Subject: RE: 10053: Toddington Lane Littlehampton, Arun District, BN17 7PN APP/C3810/W/18/3197149 (LU/162/17/PL) Condition 14

From: Andrew Tanner [REDACTED]
Sent: Tuesday, November 19, 2019 12:46 PM
To: [REDACTED]
Cc: Euan Clark - Folkes Architects [REDACTED]
Subject: 10053: Toddington Lane Littlehampton, Arun District, BN17 7PN APP/C3810/W/18/3197149 (LU/162/17/PL) Condition 14

I am contacting you in regards to the development at Toddington Lane (LU/162/17/PL) and condition 14. In your comments on 15th October 2019 you asked for A visibility splay of 2.0m * 66m in both directions at the western end of the proposed footway. This was to ensure any pedestrians crossing in this location have sufficient visibility to see any oncoming cars. The 66m visibility splay is achievable looking west but not looking east.

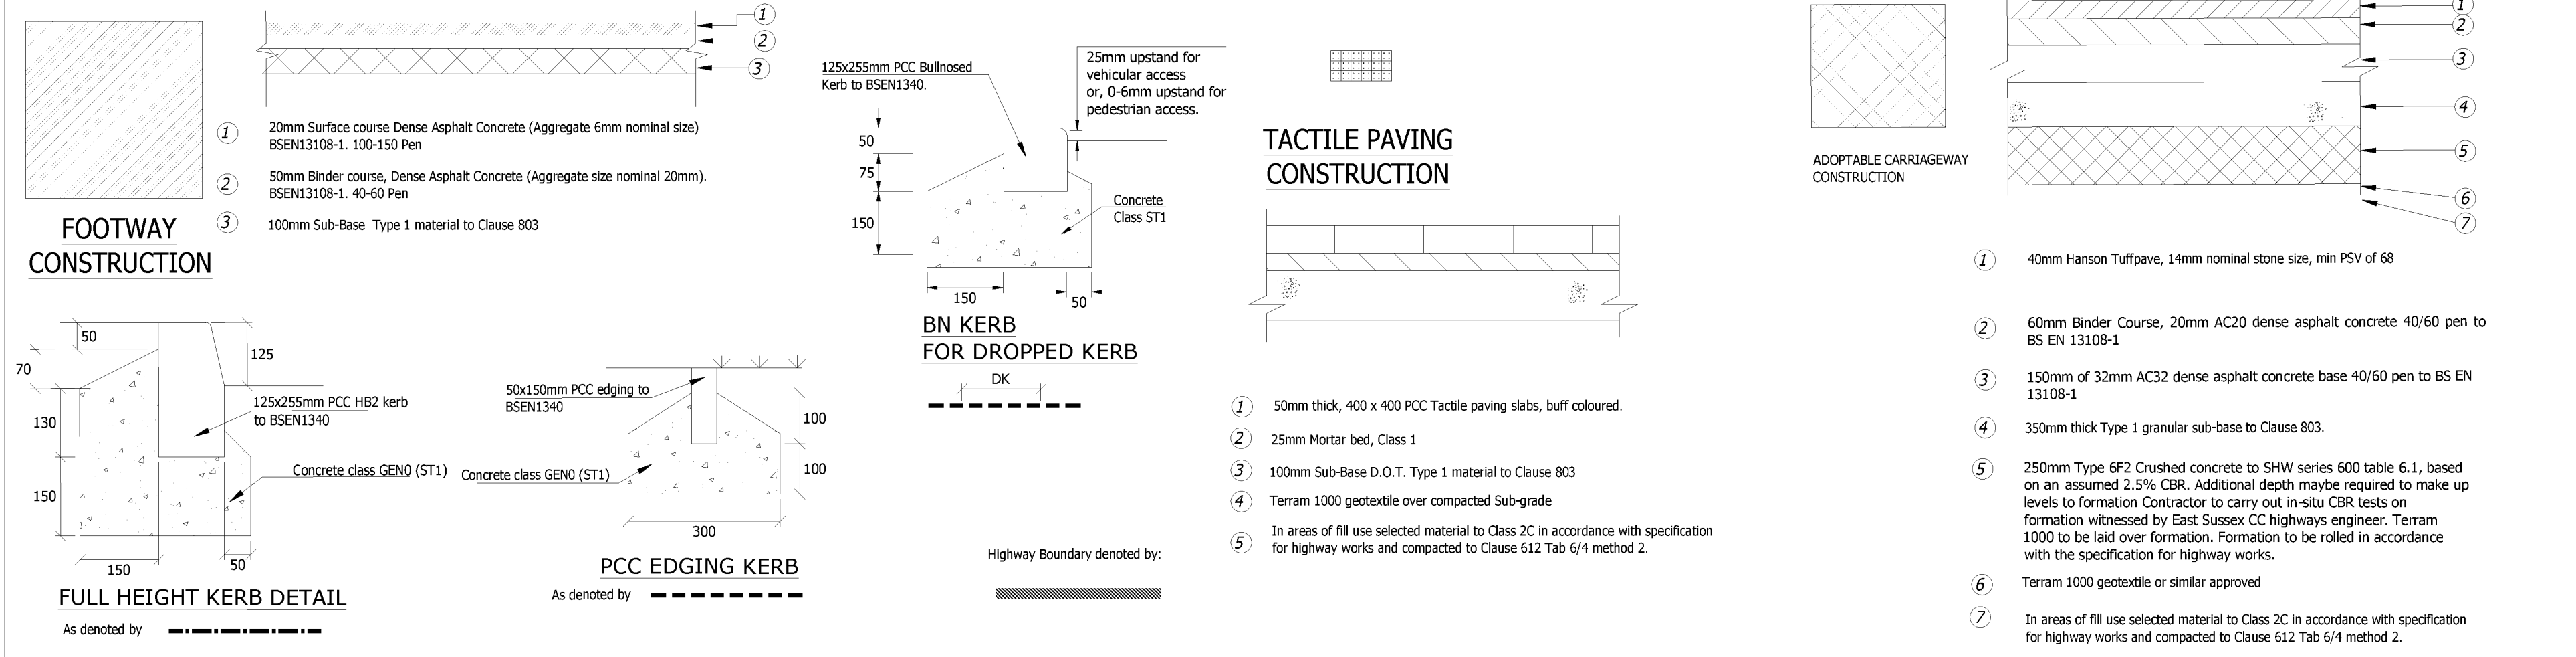
We have had a speed survey completed on Toddington Lane to assess if the 30mph speed limit you based the visibility splay on was accurate to the actual speeds. Please see the ATC data attached. The ATC indicates that the mean speed for westbound traffic is 24mph and the 85thile speed is 28mph (7 day mean). It should be noted that the position of the ATC was further to the west than the position of the proposed crossing and is likely in a location where vehicles are accelerating out of the corner. The vehicles speeds at the proposed crossing point are actually likely to be lower than 28mph.

I note that section 4 of WSCC design guide states that lightly trafficked residential roads have 85thile speeds below 37mph, can have MfS1 standards applied. As this is the case for Toddington Lane, the 66m visibility splay is likely in excess of the stopping sight distance for westbound vehicles will need to see pedestrians. Using MfS1 standards and the recorded 28mph 85thile speed there is a stopping sight distance requirement of 39m.

I also note that the visibility splay asked for is from 2.0m, the proposed footway is 2m in width and it is unlikely a pedestrian would be stood on the back edge of the footway, would a visibility splay from 1.0m be acceptable as this is likely to be more reflective of a pedestrians position on the footway.

With the above in mind I would suggest a 1.0m * 39m visibility splay should be acceptable and allow for the crossing point to function safely. Please see update site layout with the visibility splays, I have shown 66m looking westwards as this is achievable and 39m is achievable looking east. Please note I have shown the 39m visibility splay to 600mm off of the kerb to represent the likely position of a car.

Would the proposed visibility splay be suitable?
